From: Amanda Scholes on behalf of Planning.Responses
Sent: 01 June 2020 12:04
To: Planning Scanning
Subject: FW: *EXTERNAL: RE: BN/18/20/PL, Former Brooks Nursery

In terms of the proposals effect on the existing suds (surface water drainage system), I would like to make the following comments;

A	21.05.19	Bellmouth amended	HJS
REV. No.	DATE	DESCRIPTION	INITIALS
Client	 BARRATT HOMES		
Project	Brooks Nursery Barnham		
Title	Foul Outfall Rising Main Details		
Scale	1:250	Date	Sept '18
Checked	AMc	Drawn	AMc
Drawing No.	4482:510	Rev	A

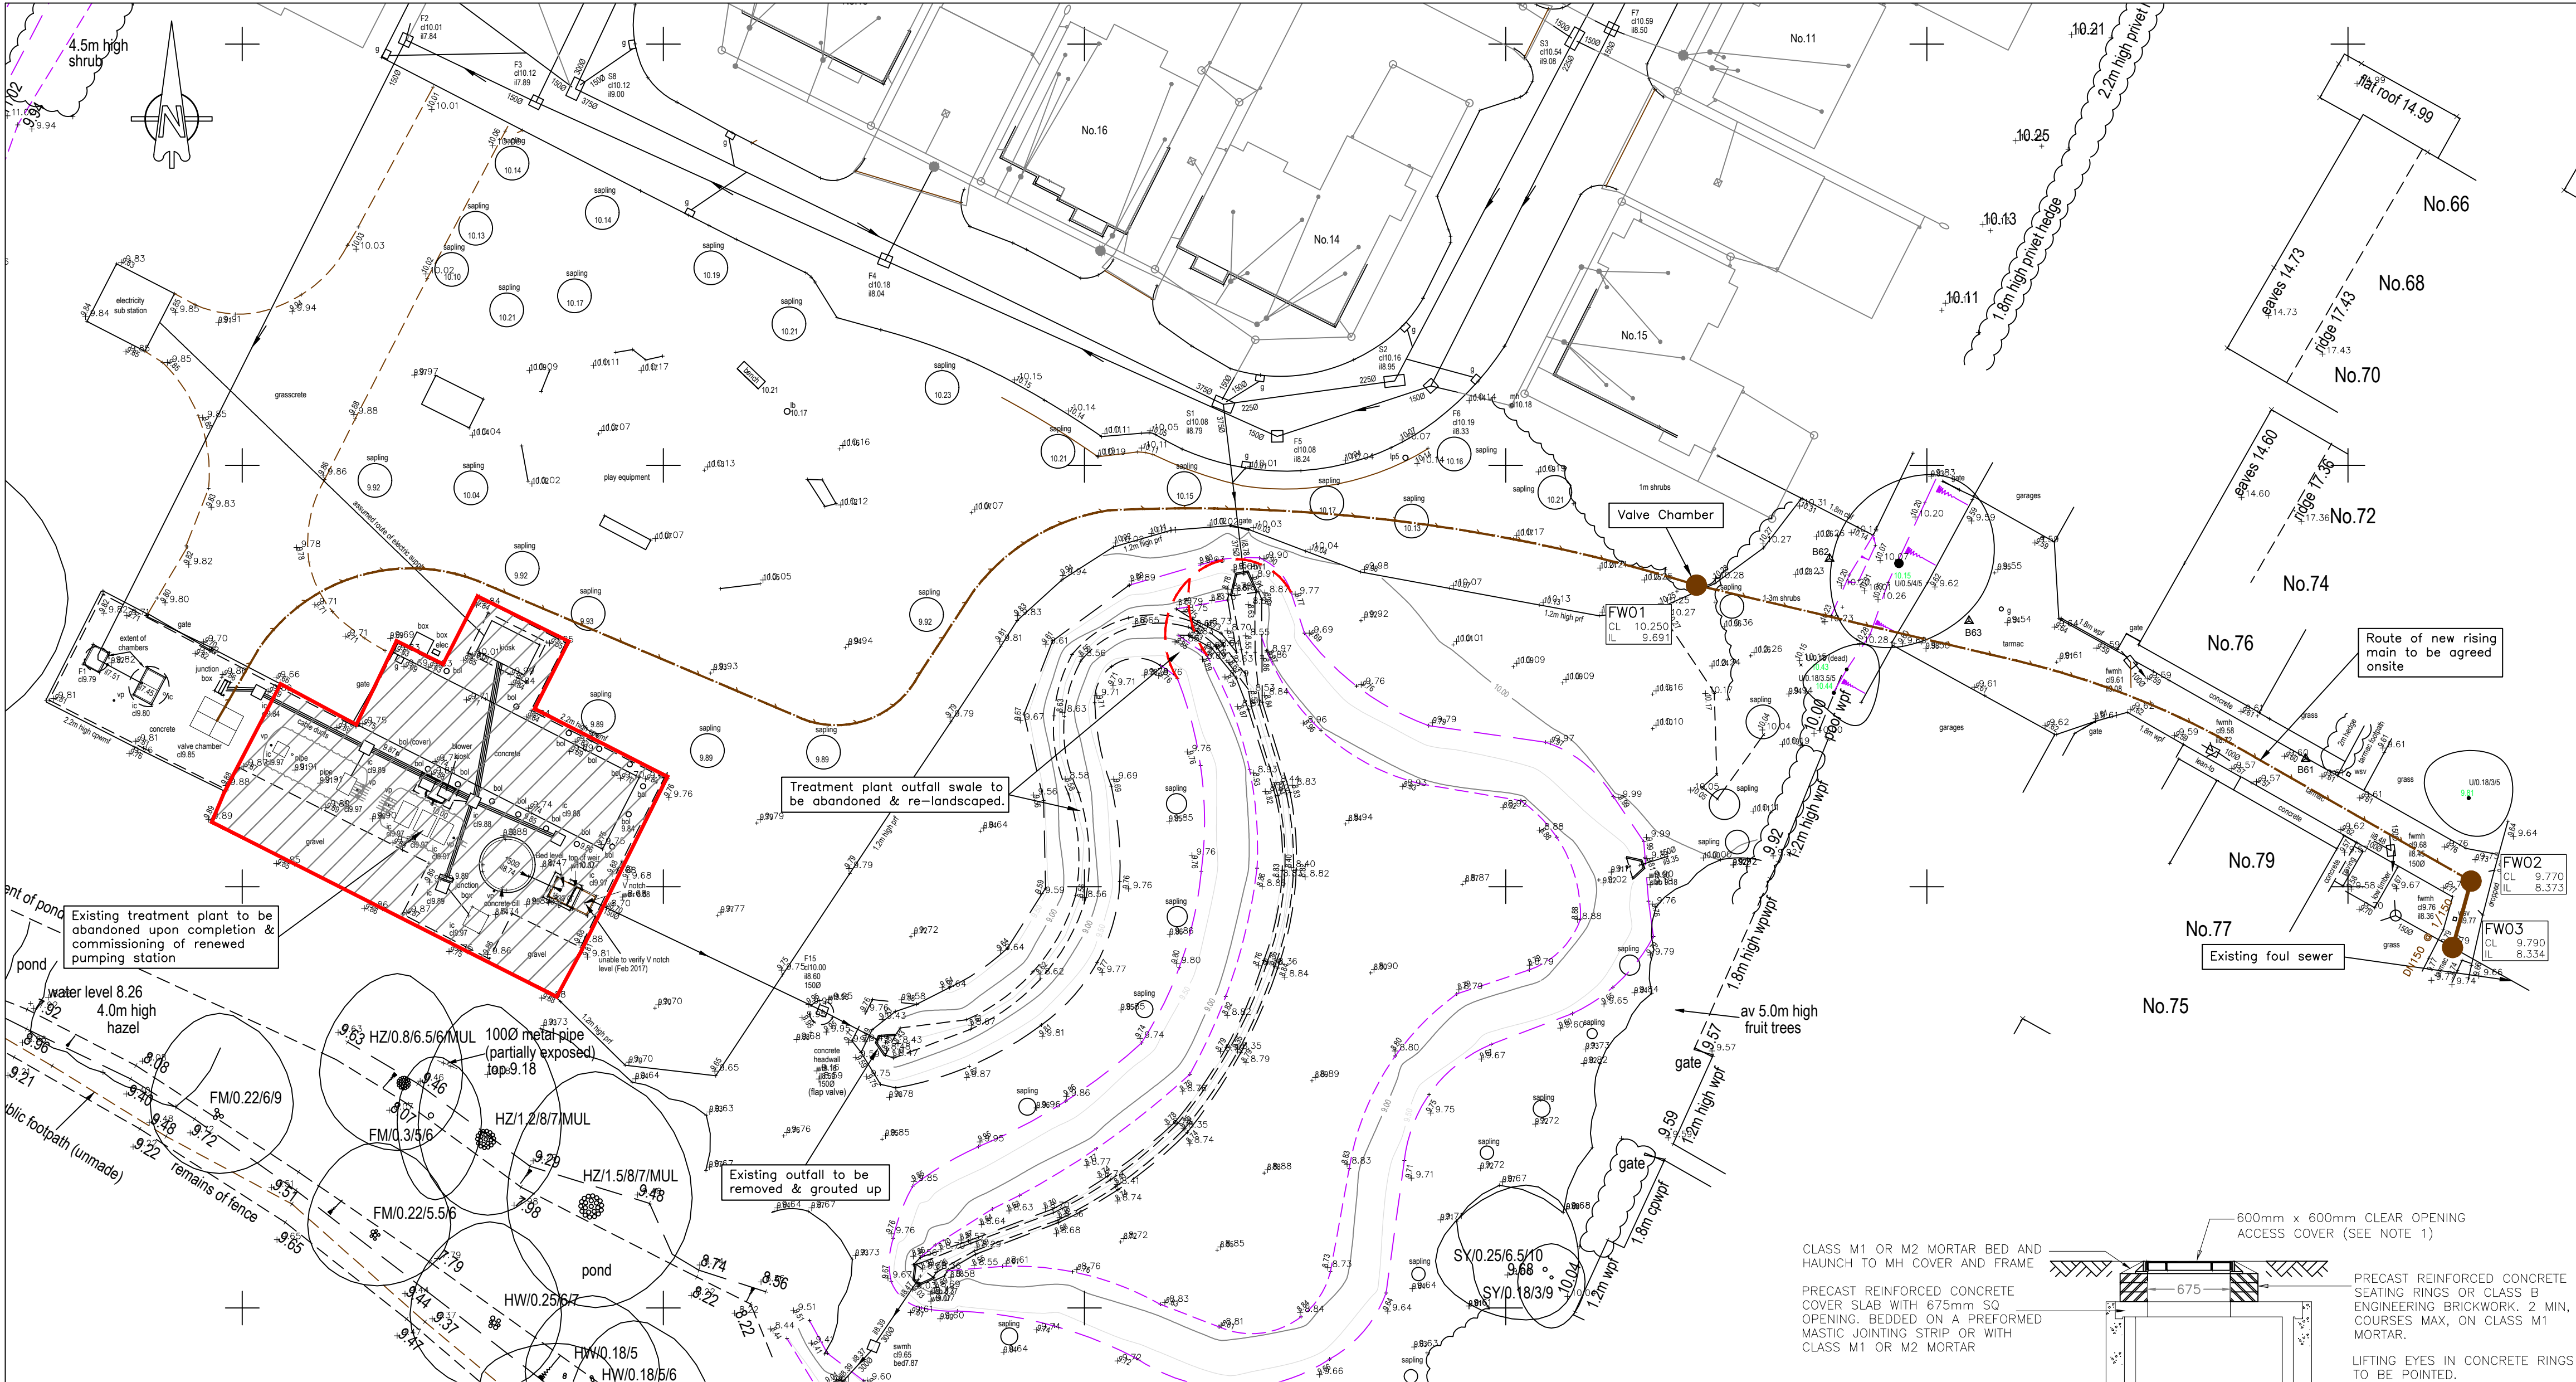
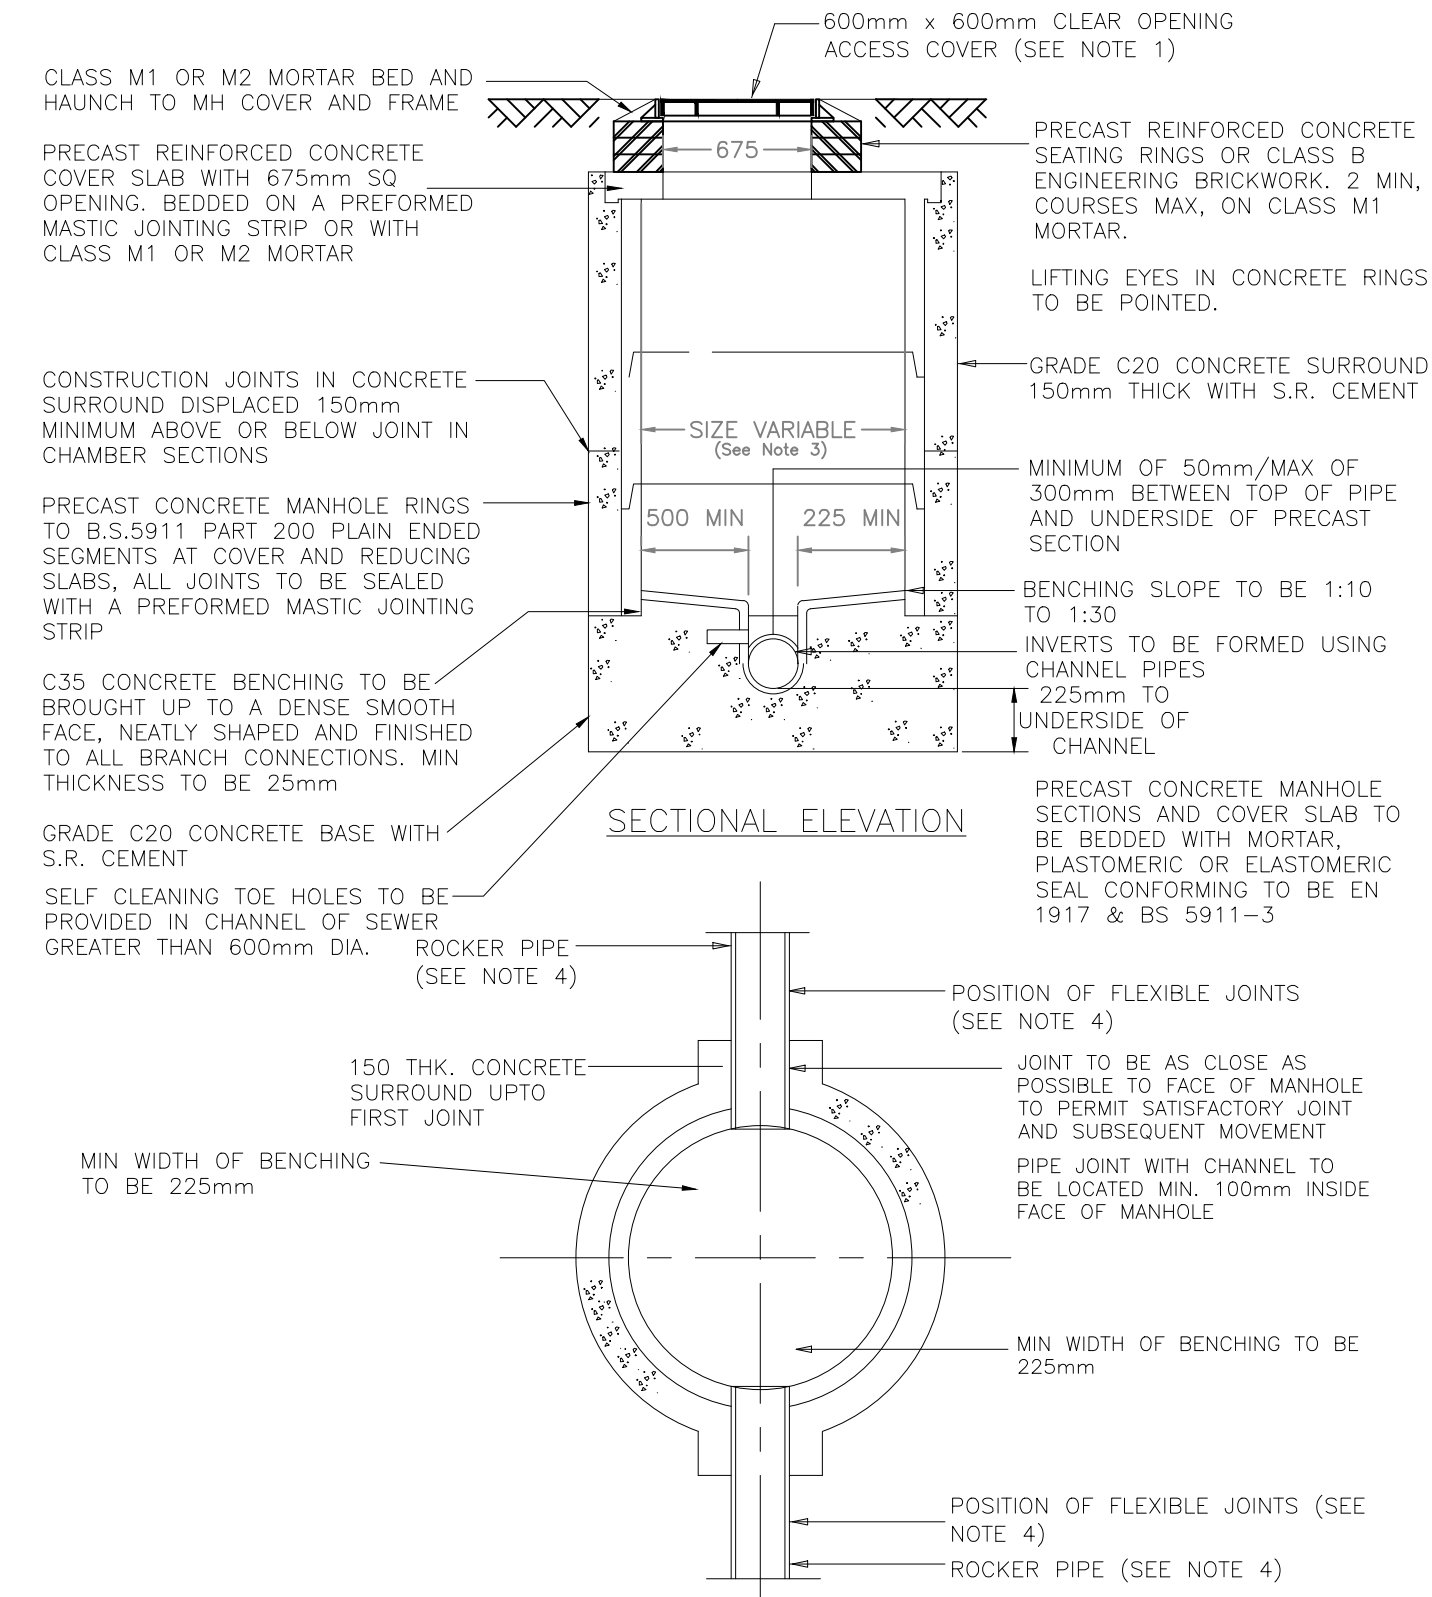
I will ask our engineer for the long section to incorporate the land drain requested

- a) The open channel/ditch in which the sewage treatment plant discharges into at present, before it connects into the suds pond, is proposed to be infilled.
The applicant will need to provide written confirmation with supporting calculations to prove that the storage for surface water within the suds system is not compromised as a result.
- b) Where the proposed rising crosses the incoming surface water outfall to the pond and the known land drain running parallel to the eastern boundary of the development, the applicant should provide a longitudinal section to prove no impact on these pipelines.

Finally, the long section requested was already shown on drawing no, 4482.510A , which I attach for reference along with the other engineers drawings which were agreed at the meeting
